Subject: FW: A/50/20/PL - Variation of Condition 2 in respect of A/51/18/PL, Pound Place, Roundstone Lane, Angmering, BN16 4AL

Environmental Health.

Noise Report.

ISOMETRIC VIEW

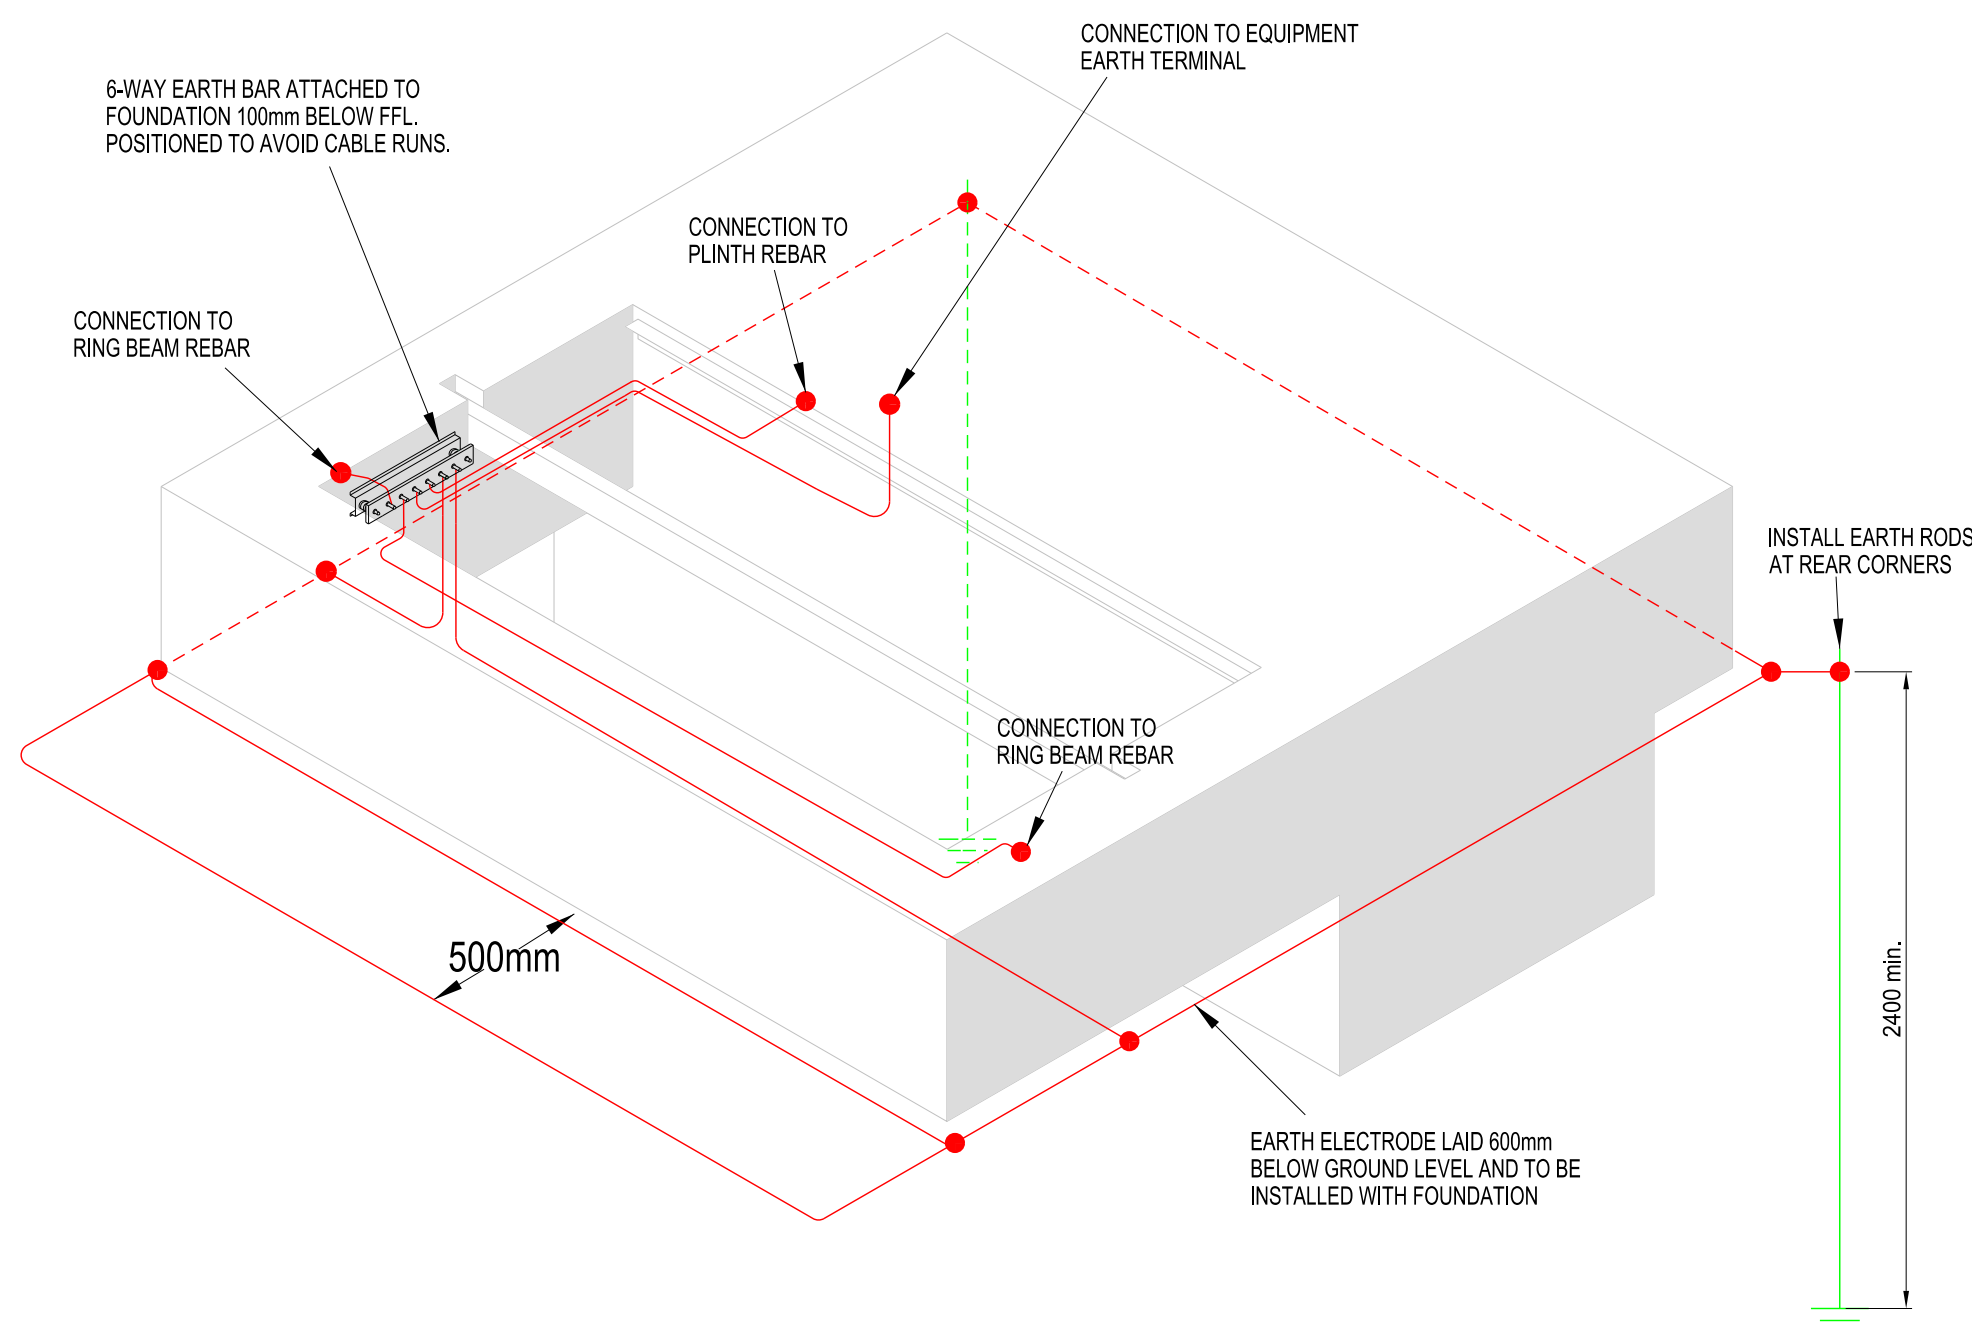
1. Prior to the first use of the electricity substation, an acoustic report assessing the impact shall be submitted to and approved in writing by the Local Planning Authority. The report shall address the issue of noise (including low frequency noise) and vibration from the station to ensure that there is no adverse effect to residential or commercial properties

For residential accommodation, the scheme shall ensure that the low frequency noise emitted from the substation is controlled so that it does not exceed the 'Low Frequency Criterion Curve' for the 10 to 160 Hz third octave bands inside residential accommodation as described in the DEFRA funded University of Salford Manchester guidance document entitled 'Procedure for the Assessment of Low Frequency Noise Complaints' (NANR45 Rev.1 – December 2011).

The electricity substation equipment shall be maintained in a condition so that it complies with the levels and mitigation measures specified in the approved acoustic report, whenever it is operating. After installation of the approved plant, no new plant shall be used without the written consent of the Local Planning Authority.
